ATLASSIAN OFFICE AND HOTEL DEVELOPMENT SSD-10405 MOD 2 - APPLICANT RFI RESPONSE

This letter has been prepared by Urbis on behalf of Vertical First Pty Ltd in response to the Request for Additional Information (**RFI**) from the Department of Planning and Environment (**DPE**) dated 1st November 2022.

The RFI request is in relation to a Section 4.55(1A) modification application (MOD 2) for the approved State Significant Development (SSD-10405) which approved an office and hotel accommodation development at 8-10 Lee Street, Haymarket.

1.1 FIGURE 1 - PROPOSED BASEMENT LEVEL 2 PLAN (CONTINUED)

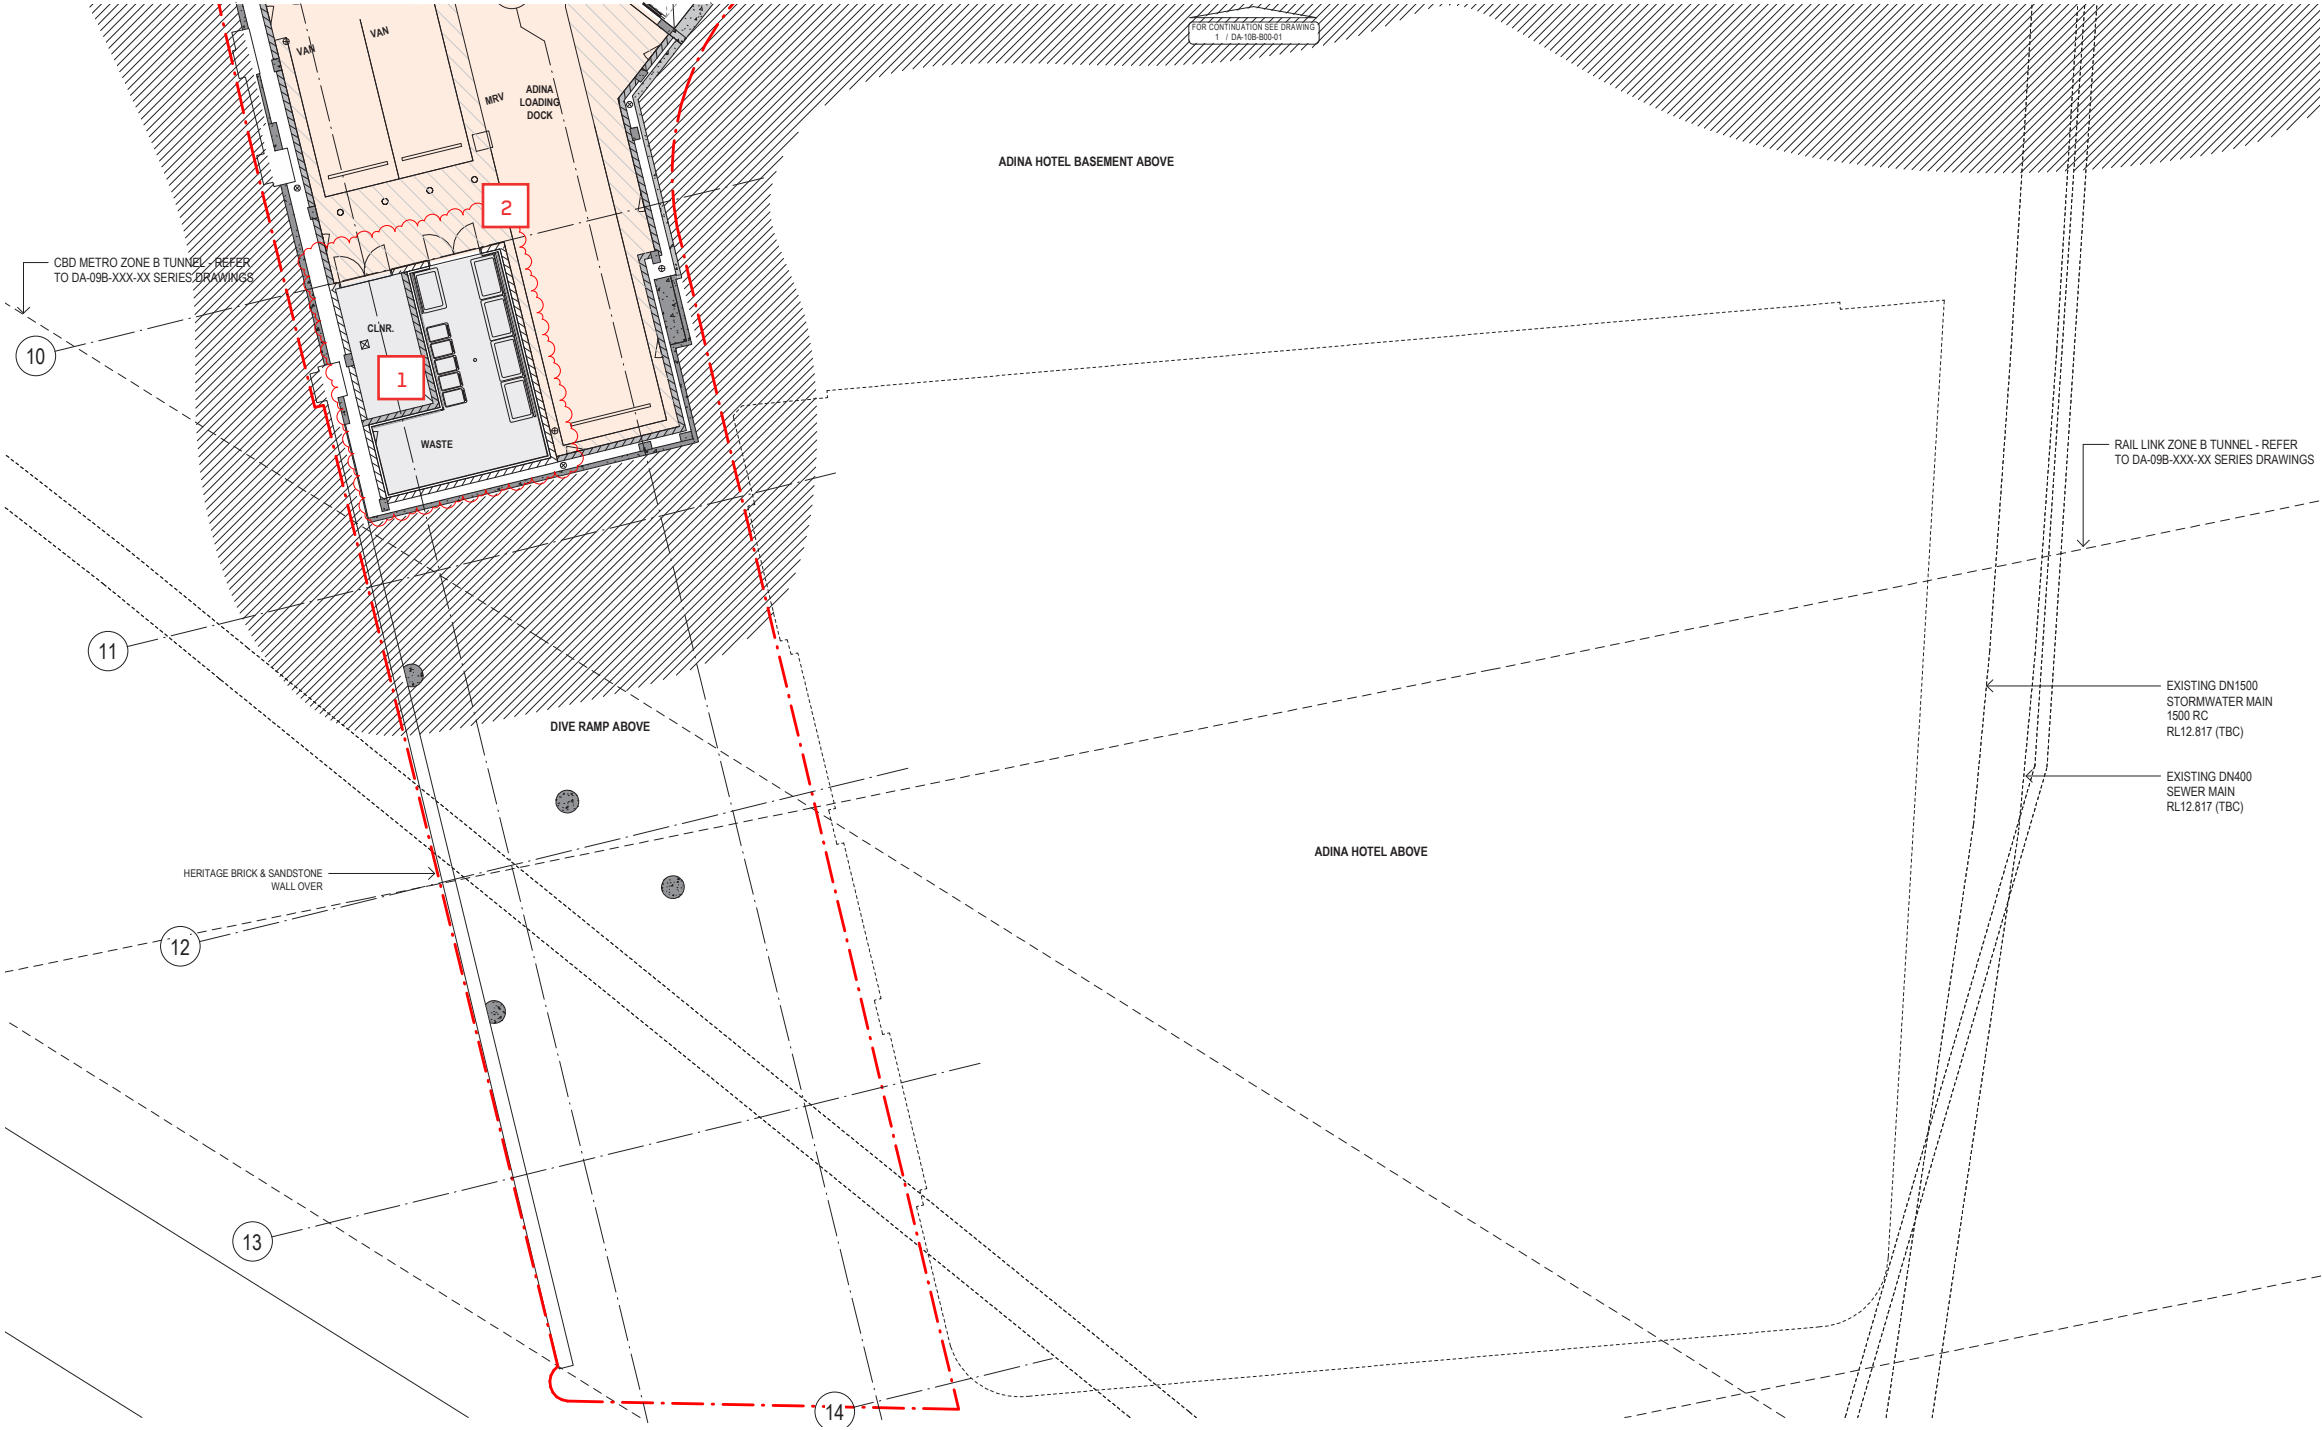
Issue	Response
City of Sydney	
<p><u>Waste Management</u></p> <p>Regarding the City's concern about the reduction in the Adina loading area in front of the waste room at Basement Level 2 and adequate space for a vehicle and the movement of bins, the proponent has responded by stating that a 2 metre clearance would be available between the parking space and wall for loading of the bins where collection vehicles reverse into the parking space. However, this clearance does not appear to be provided on the architectural plans with only approximately 1.15 metres provided, which may make manoeuvring bins difficult. It is requested that the proponent clarify this discrepancy and amend the clearance to 2 metres on the plans.</p> <p>It is considered that the other issues raised regarding operational waste management (post construction) may largely be able to be resolved via Waste Management Plans for each future business prior to occupation. It is acknowledged that the proponent has accepted that commercial waste will be collected on a daily basis, therefore a larger waste storage area is not required.</p>	<p>The Basement 2 plans have been updated to show a 2.6m clearance between the parking space and wall for loading of bins.</p> <p>It is noted that vehicles will enter the Adina MRV bay in a forward facing direction and reverse to exit.</p> <p>A note has been added to the Basement 2 plans clarifying the vehicle loading area as well as clear dimensions of the MRV bay (10m) and circulation area in front of the Adina waste room.</p> <p>See DA-09B-B00-00(10) and DA-10B-B00-02(9) at Appendix A.</p>
